January 10, 2025

Re: Pedestrian Level Wind Study Memo
1950 Scott Street, Ottawa
Gradient Wind File 18-031

Landscape
Plan / TCR
L1
Scale: 1:125

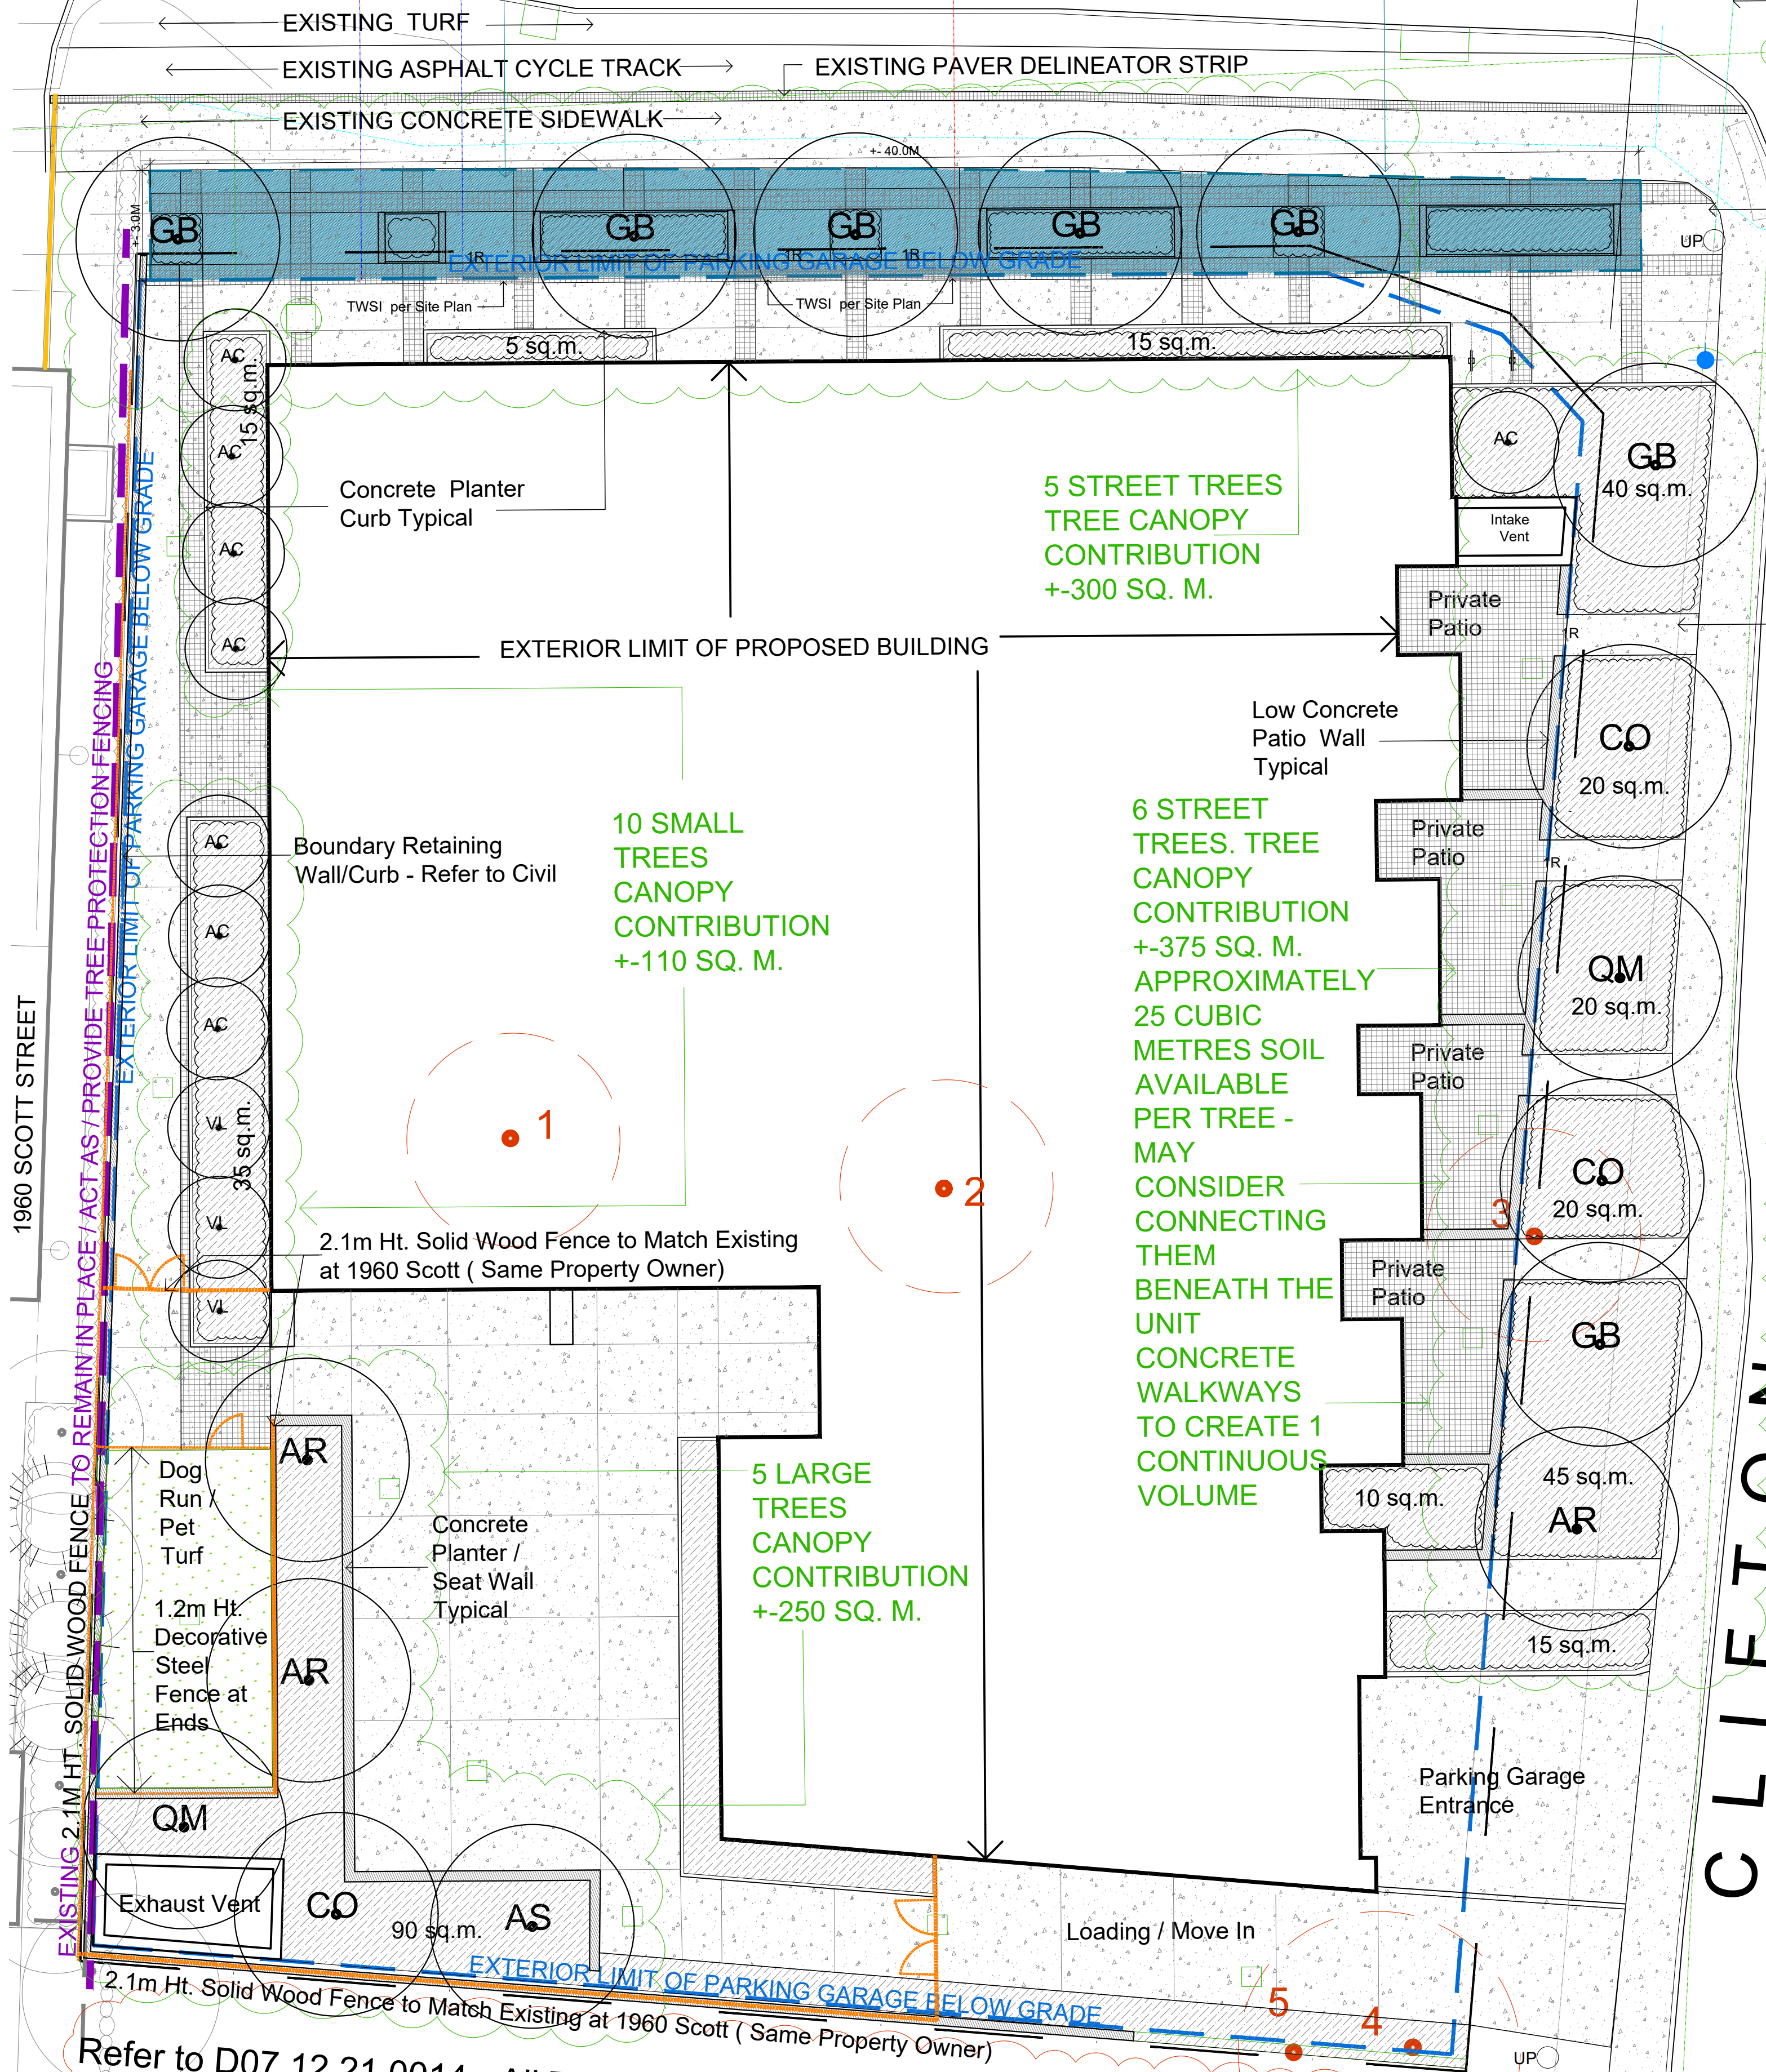
"Please have Wind Consultant review recently provided Landscape Plan and comment on types of plantings and structures that are planned for ground level amenity space area and provide a signed/stamped Eng. Addendum Letter or Memo. On what is proposed and/or additional recommendations. We would like to ensure that proposed plantings are sufficient to provide a suitable

wind screen from wind that would adversely affect occupants of this space. We see Maple, Oak and Berry trees being proposed, yet recommendations from consultant speak to coniferous trees (and/or dense vegetation).”

In coordination with the wind consultant, several mitigation elements for the ground level outdoor amenity have been incorporated into the landscape plan⁵: (1) a 2.1-metre (m) tall solid wood fence with a gate extends to the property line from the southwest corner of the building; (2) a similar 2.1-m-tall gated fence extends to the south property line from the south building façade, with both gates connecting to the existing and proposed solid wood fence along the western and southern property lines; and (3) a 2.1-m-tall wood fence is included along the east elevation of the dog run.

In combination with the extension of the existing fence along the south property line and the proposed vegetation at the perimeter of the outdoor amenity, these three elements are expected to be effective in mitigating the isolated predicted windier conditions along the western and southern extents of the outdoor amenity. The resultant wind conditions within the outdoor amenity are expected to be suitable for mostly sitting during the typical use period (May to October, inclusive), which may be considered acceptable.
